**ALBUQUERQUE
PLANNING DEPARTMENT
August 6, 2008
DRB Comments**

ITEM # 17

PROJECT # 1007400

RE: Lots 10 – 12, Block 12, Albright & Moore Addition

CONCEPT SITE PLAN - REPLAT OF LOTS 10, 11 & 12, BLK 12 ALBRIGHT - MOORE ADDITION

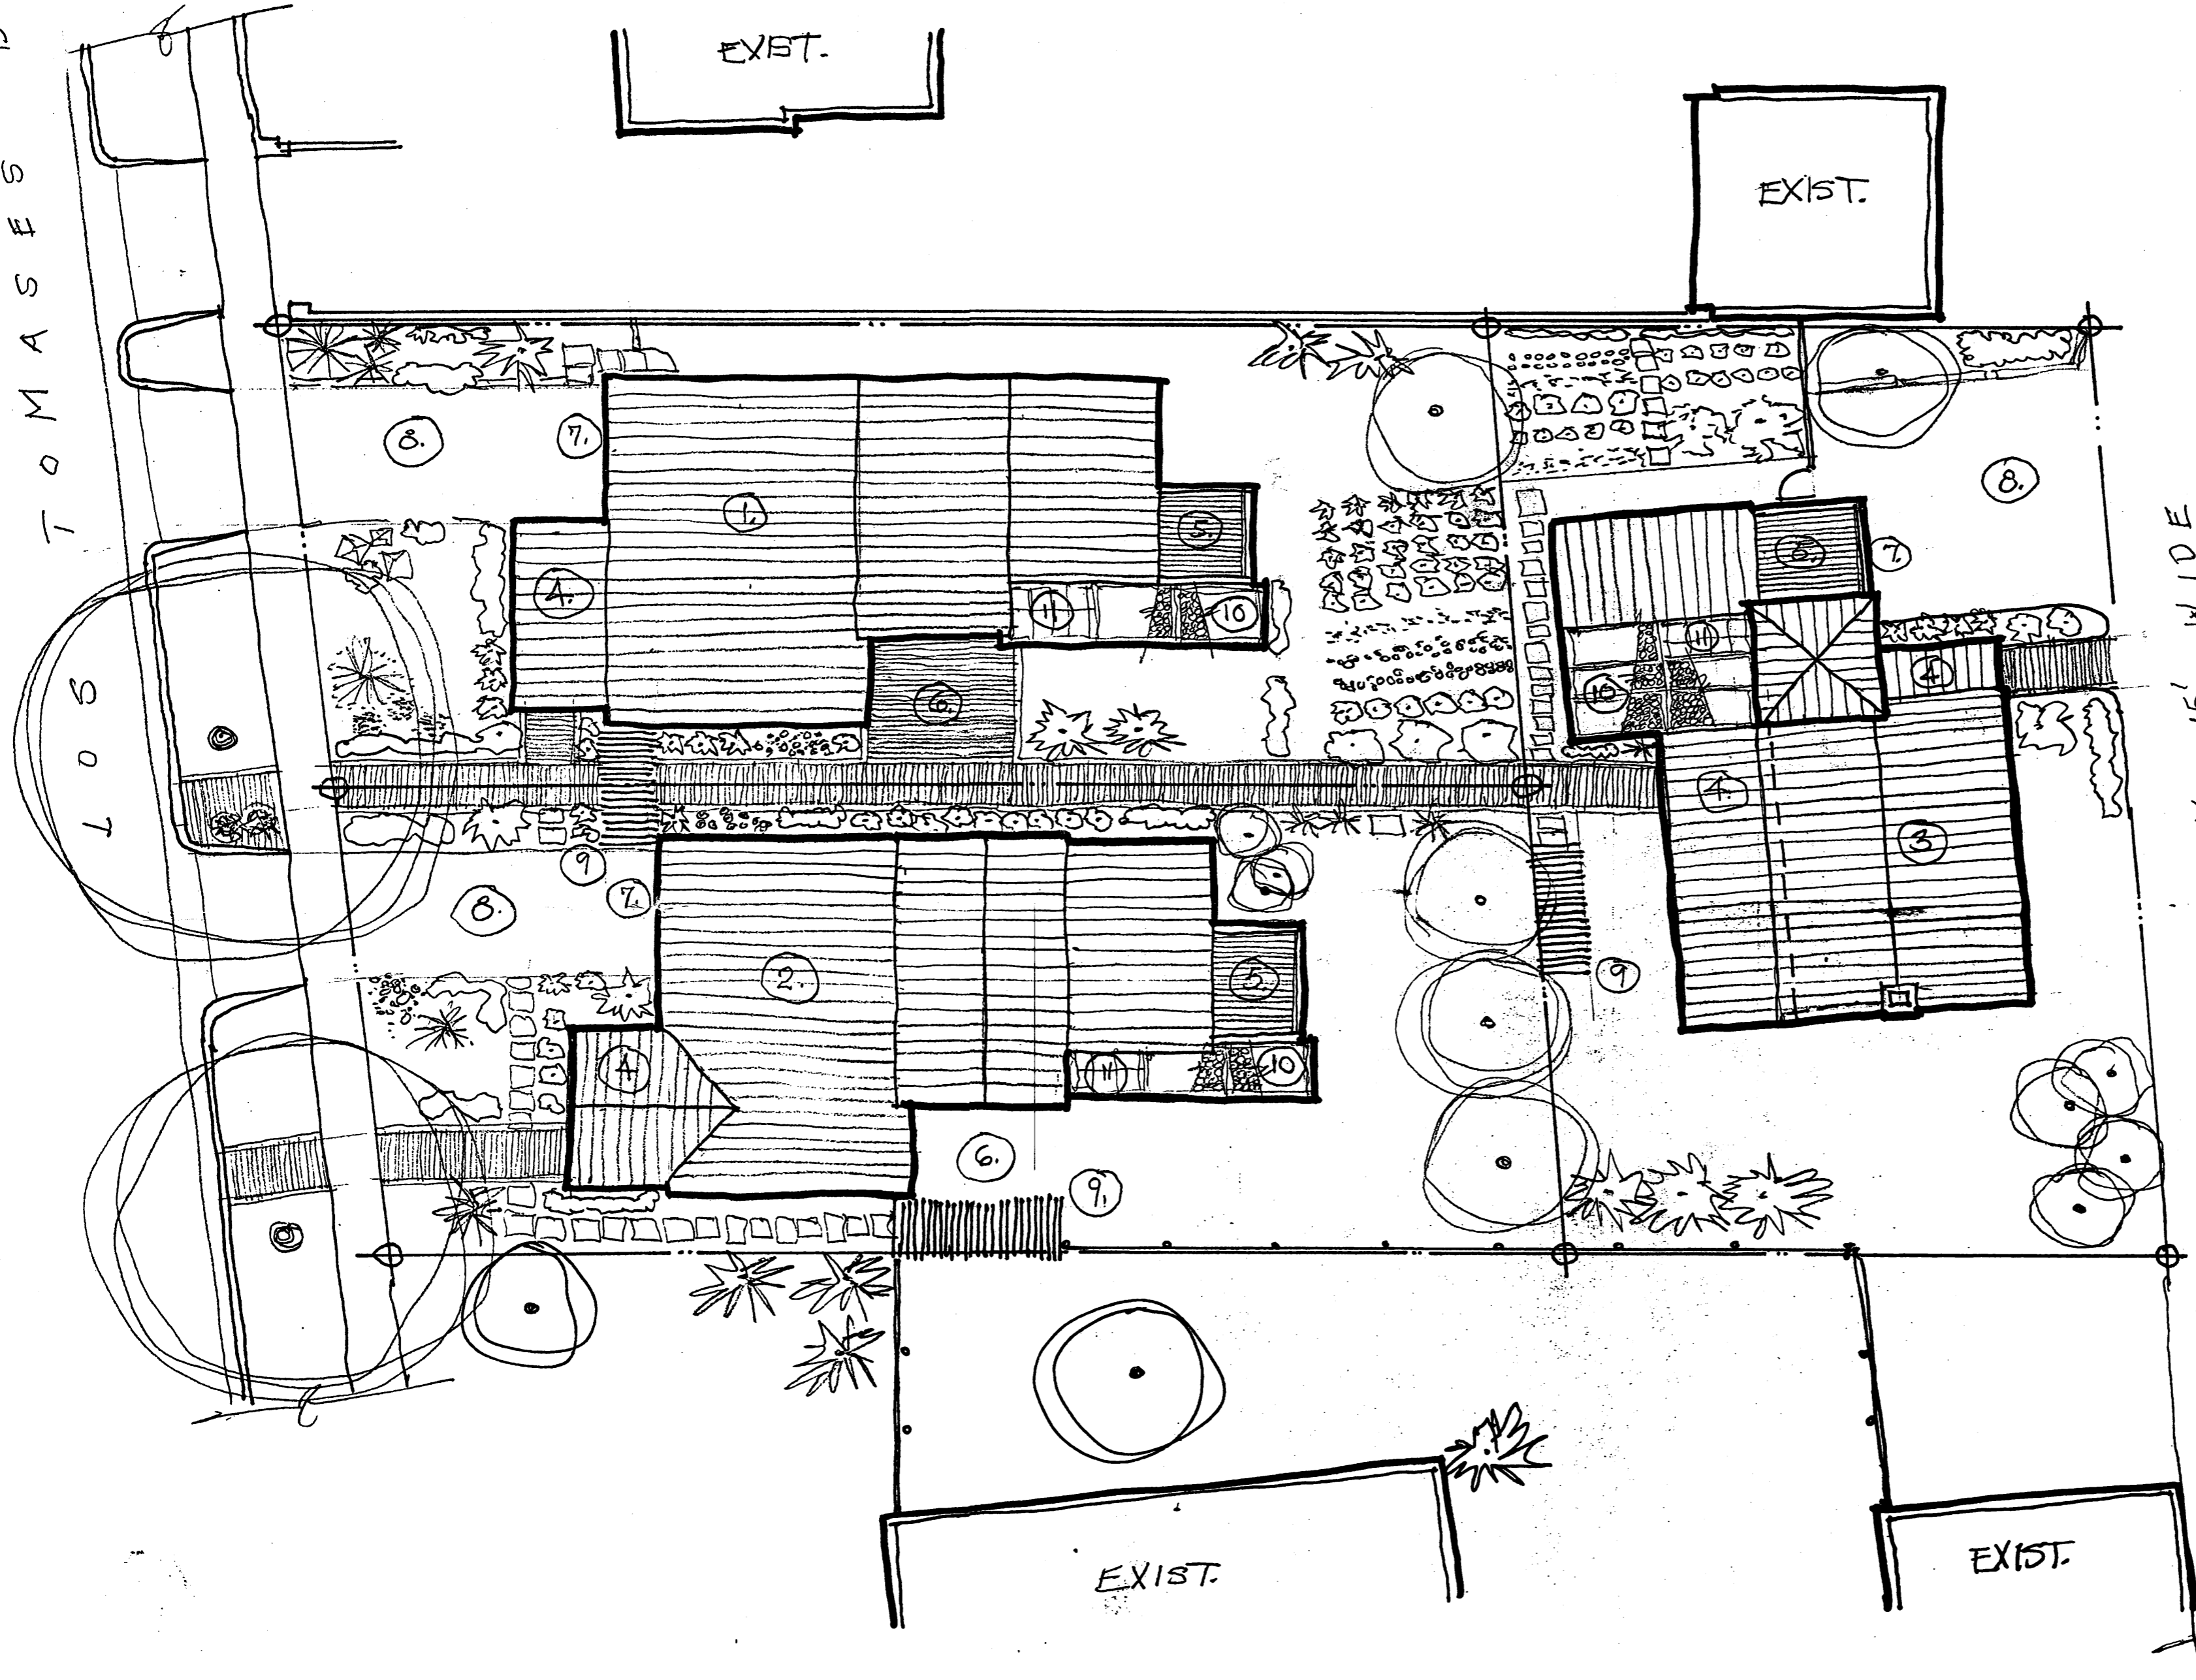
A brief review of the plan did not indicate that primary access is allowed from an alley; typically a lot must front a street, or have access to a street via an access easement. In other words, the proposed alley lot does not have a front lot line.

The S-R zone allows detached single family dwellings per the R-LT zone, which would allow two lots (which could include access from the alley).

An approved grading and drainage plan is required for Preliminary Plat approval.
